**From:** [Kelly Bacon \(CD\)](#)  
**To:** [Wedin, Lathan](#); [steve.lathrop1](#) [steve.lathrop1](#)  
**Cc:** [Jeremy Johnston](#)  
**Subject:** LP-22-00001 Suncadia Phase 2 Division 7 - Request for Information  
**Date:** Wednesday, March 16, 2022 9:46:15 AM

NO. OF SHEETS	10
SHEET NO.	2

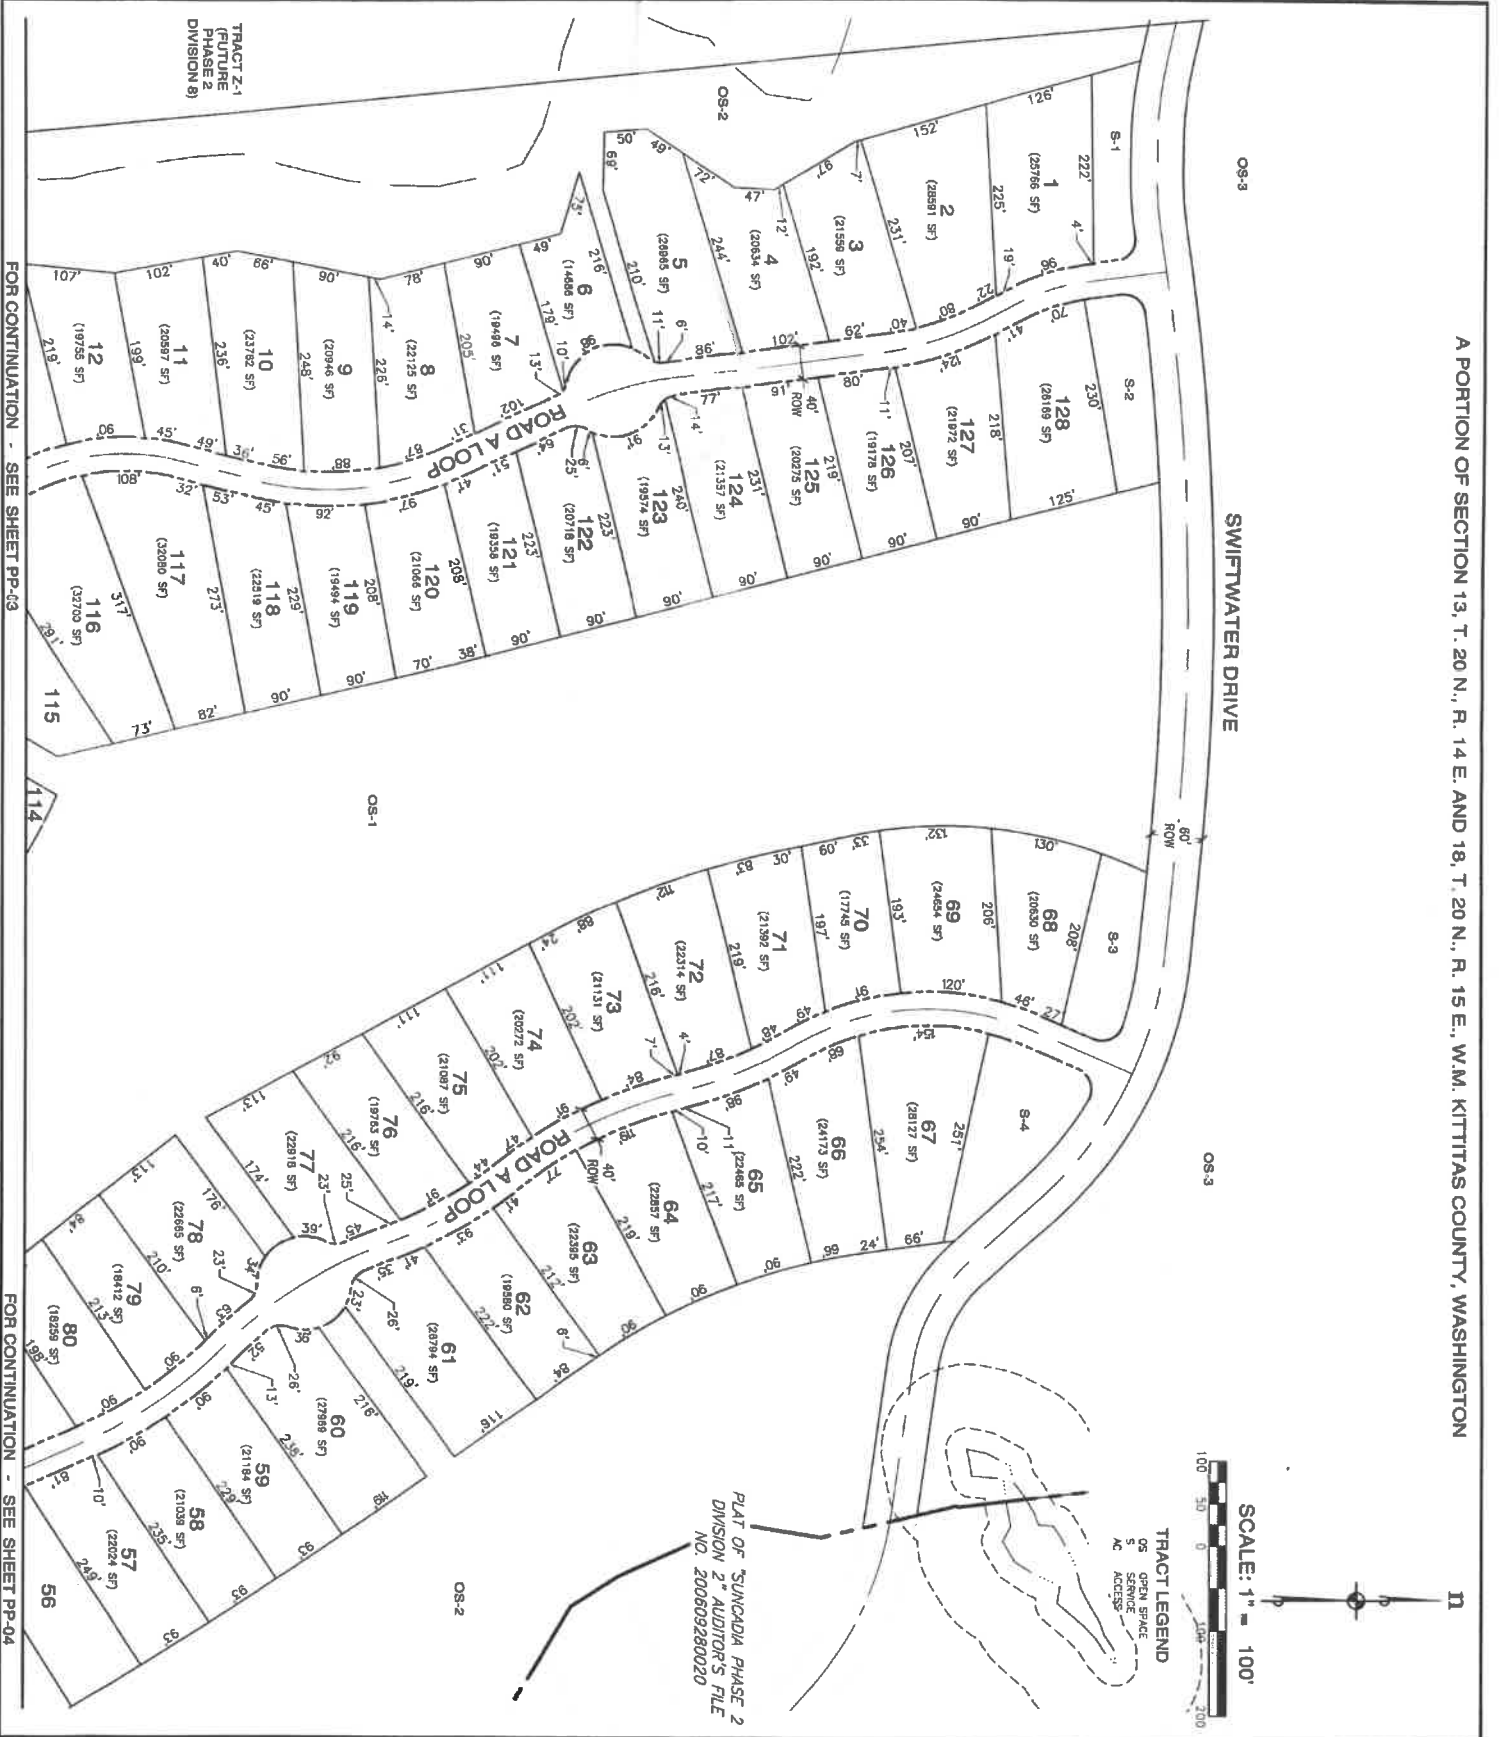
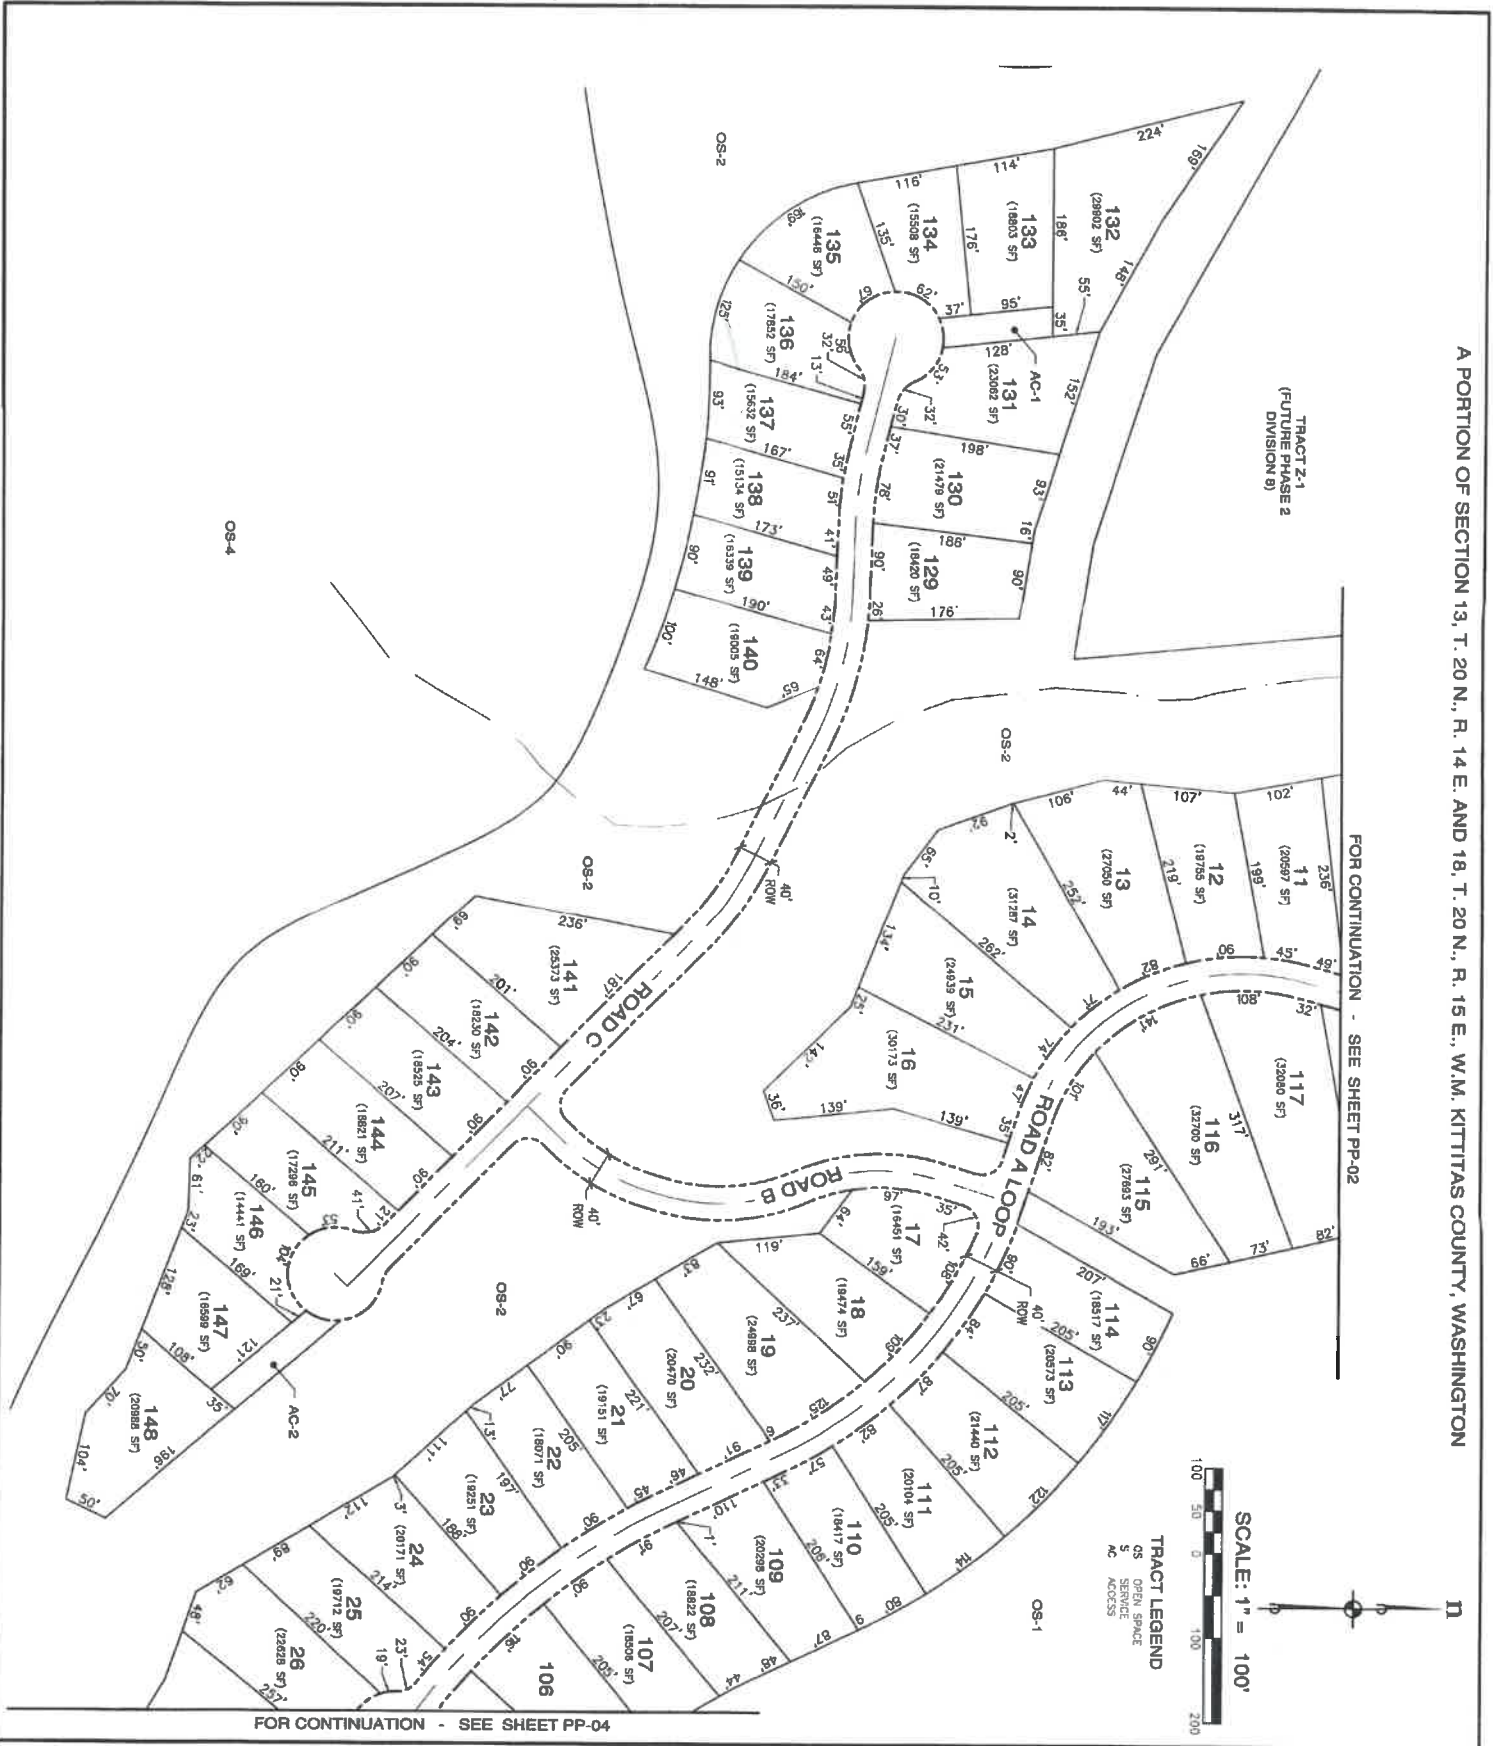
Kittitas County adopted a new Critical Areas Ordinance and the changes took effect on February 7, 2022. It is my understanding that critical areas do not vest, therefore all future development are subject to our new CAO. Due to our GIS data showing a Type 2 Stream located on the property, CDS is requesting the following information:

- Stream Delineation
- Setback buffer from the ordinary high water mark of the stream in accordance with KCC 17A.

The request for the setback buffer to be shown, allows CDS to ensure there is buildable space on the proposed new lots. In order to keep on track with the April 19<sup>th</sup> Public Hearing date, I will need the additional information as soon as possible.
